**Thames Tideway Tunnel**  
Thames Water Utilities Limited

## Thames Water's Response to Local Impact Report from City of Westminster

Doc Ref: **APP30.07**

# 1 Response to Westminster City Council's Local Impact Report

Drawing file: WW010001 / WW010001-006138-DCO-PP-16X-VCTEF-180008_Rev4_A3__Authorised.pdf

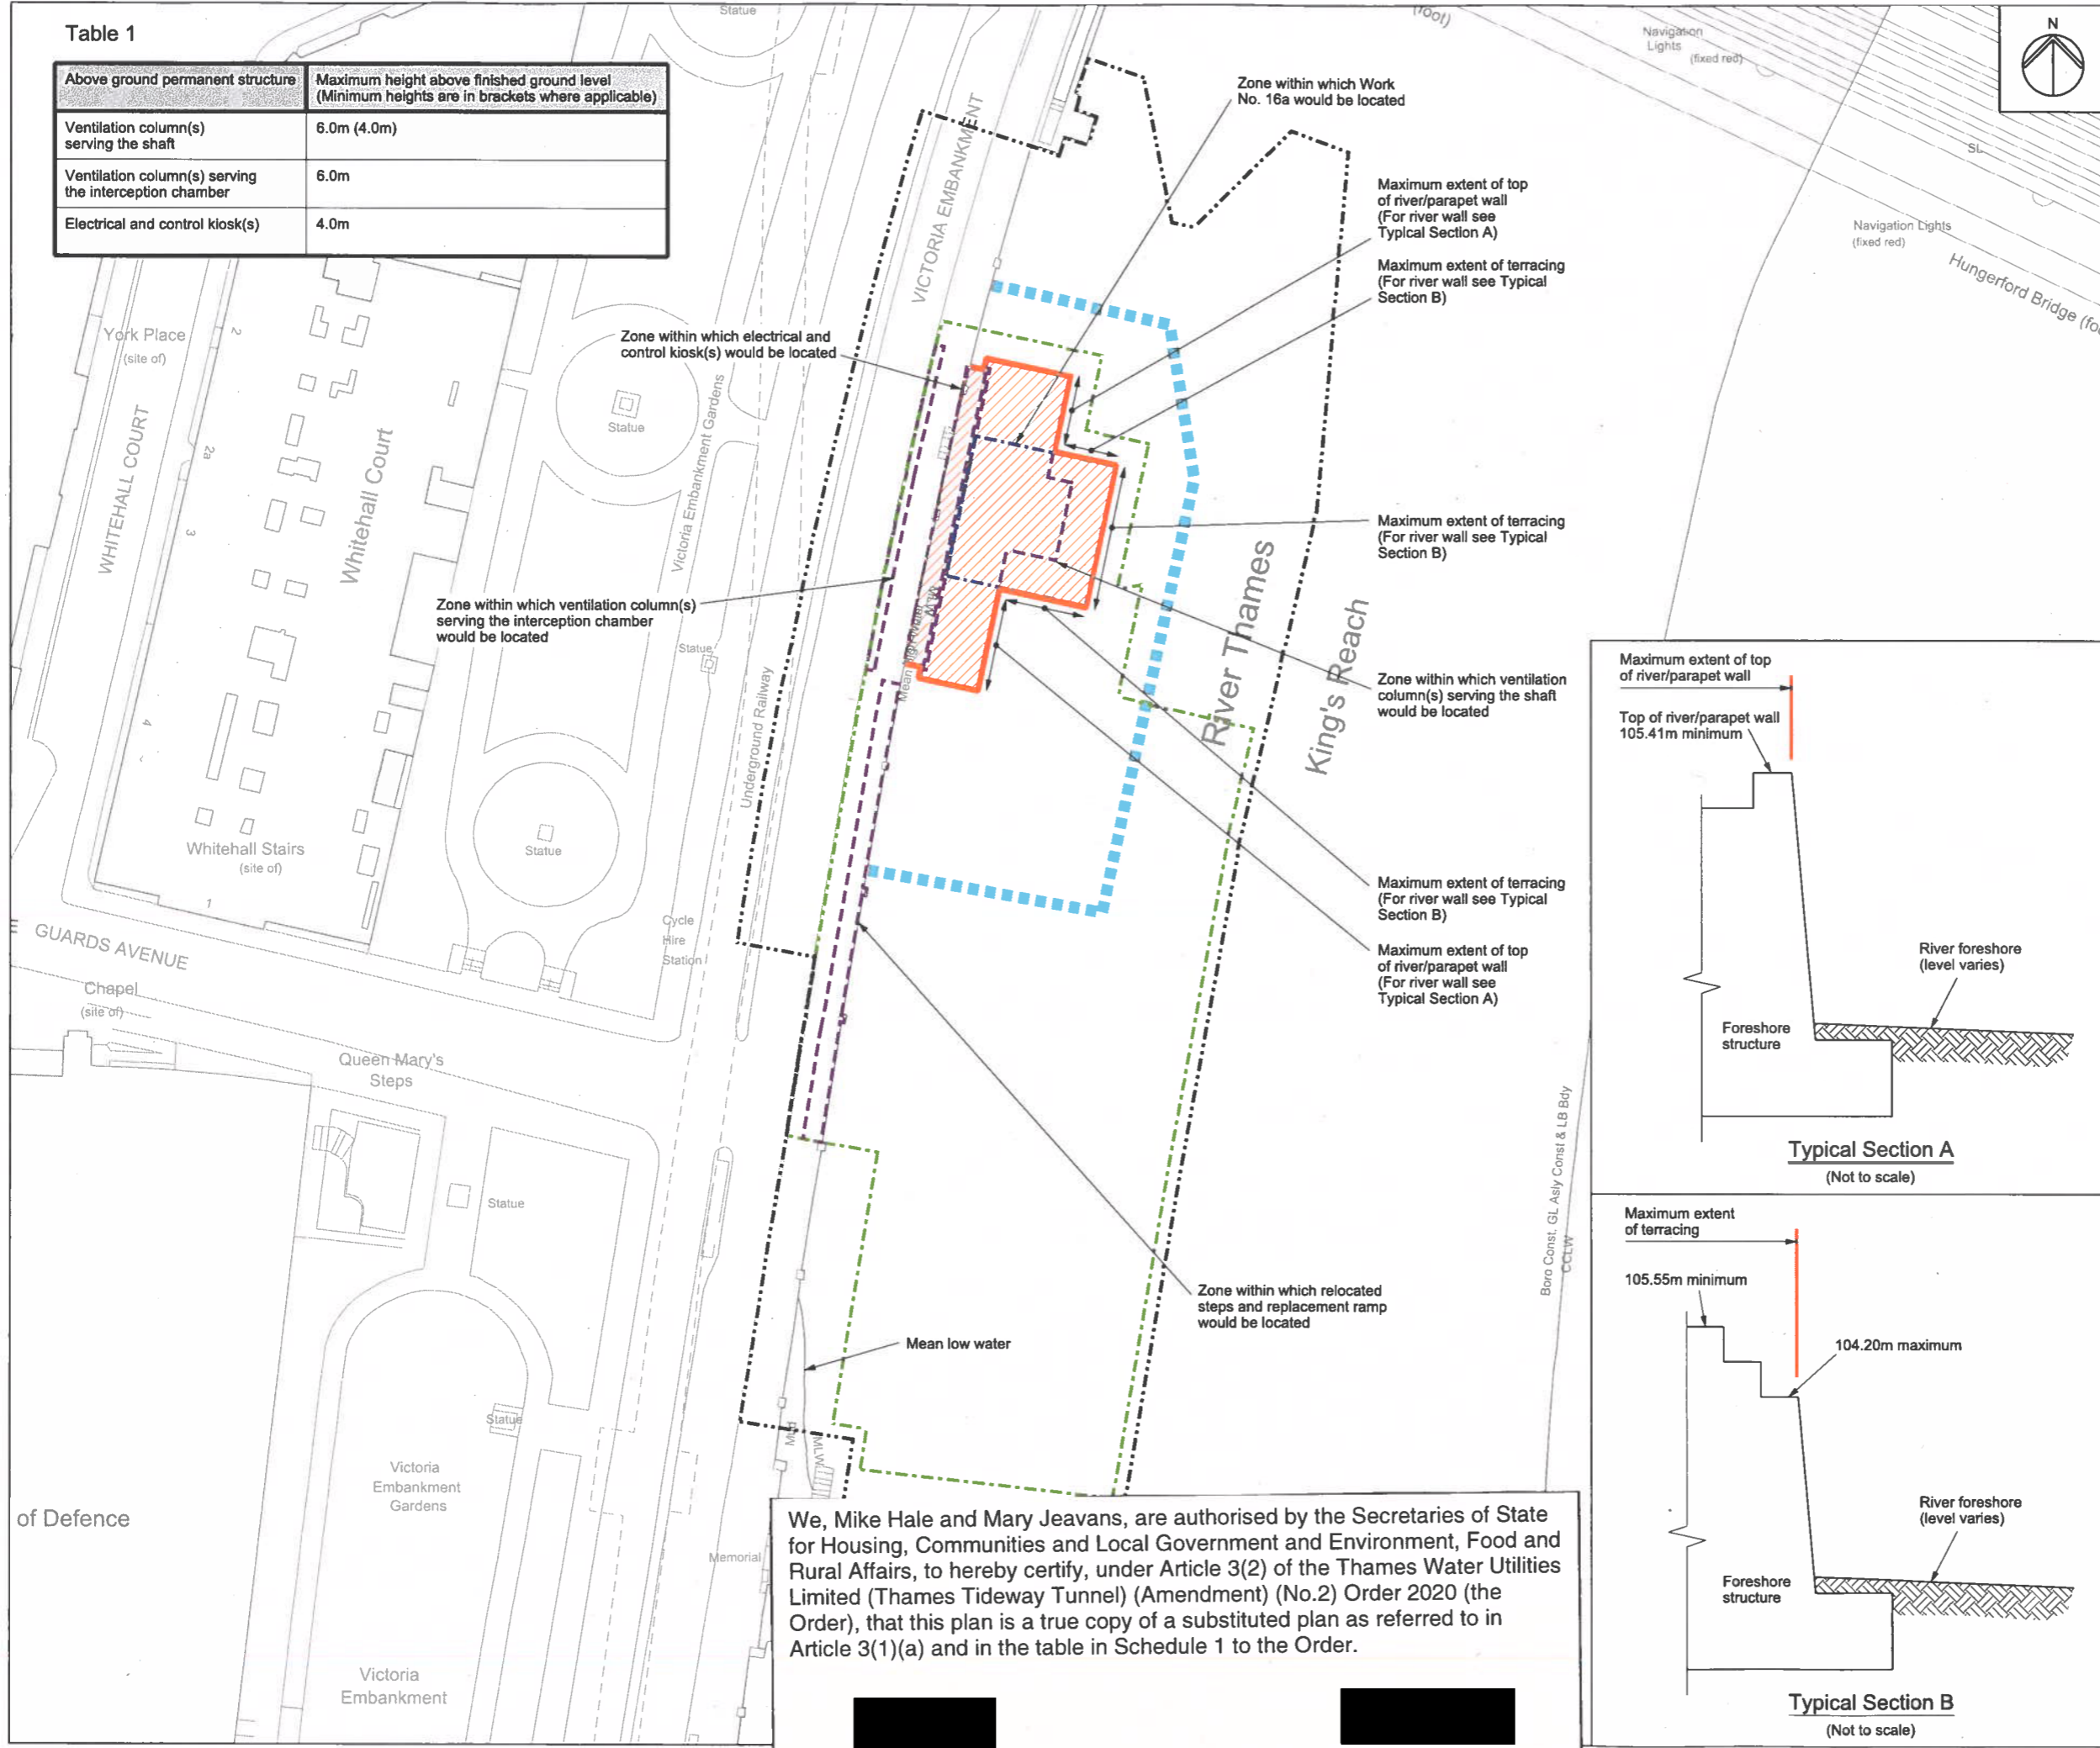
Ref	LIR section and p.	WCC comment	Our response
<b>Section 5: Impacts Assessment (Appendix 1 Impact Assessment Table)</b>			
<b>Architecture and design</b>			
1	Section 5, p. 25/26	<i>"It is felt that the lower height of 4m should be the preferred height on this site, given the sensitivity of views and townscape. It is therefore considered that a height at the lower end of the range shown i.e. closer to 4m than 6m is preferred by the City Council and this preference should be more embedded into the approved design and should form part of the site-specific design requirements.</i>	We will continue discussions with WCC. Our view is that the current Requirement is sufficient to allow these discussions to proceed towards an agreed design and no further changes to the application are necessary.
2	Section 5, p. 26	<i>"Also with respect to the signature columns it is the City Council's view that these should be finished in a dark bronze-coloured metal. It is considered that this choice of finish should be more embedded into the approved design and should form part of the site-specific design</i>	We are reviewing this and will provide a further updated version of the <a href="#">Draft DCO</a> (Doc ref: 9.20) including requirements to the ExA following the DCO Hearings in late November.

Ref	LIR section and p.	WCC comment	Our response
		<i>requirements.”</i>	
3	Section 5, p. 26	<i>“6m high kiosks are considered to be extremely harmful to the townscape and are not an aspect of the design that was presented during pre-application discussions. This aspect of the scheme must be amended with the kiosk structures having a maximum height of 3.2m.”</i>	We are reviewing this and will provide a further updated version of the DCO including requirements to the ExA following the DCO Hearings in late November.
4	Section 5, p. 26	<i>“As such it is suggested that the design of the pergola structure, which is a non-operational element of the design, should be revised.”</i>	We have agreed a new design principle with WCC (VCTEF.18) to address its concerns as follows: <i>“The pergola connecting the kiosks shall have a solid frame with lightweight interior trusses to ensure the views of the River Thames from Whitehall and Victoria Embankment Gardens are framed but not overpowered by the structure. The planting species shall be specified to ensure the entrance to the public space is shaded and welcoming and not dark and overbearing.”</i>
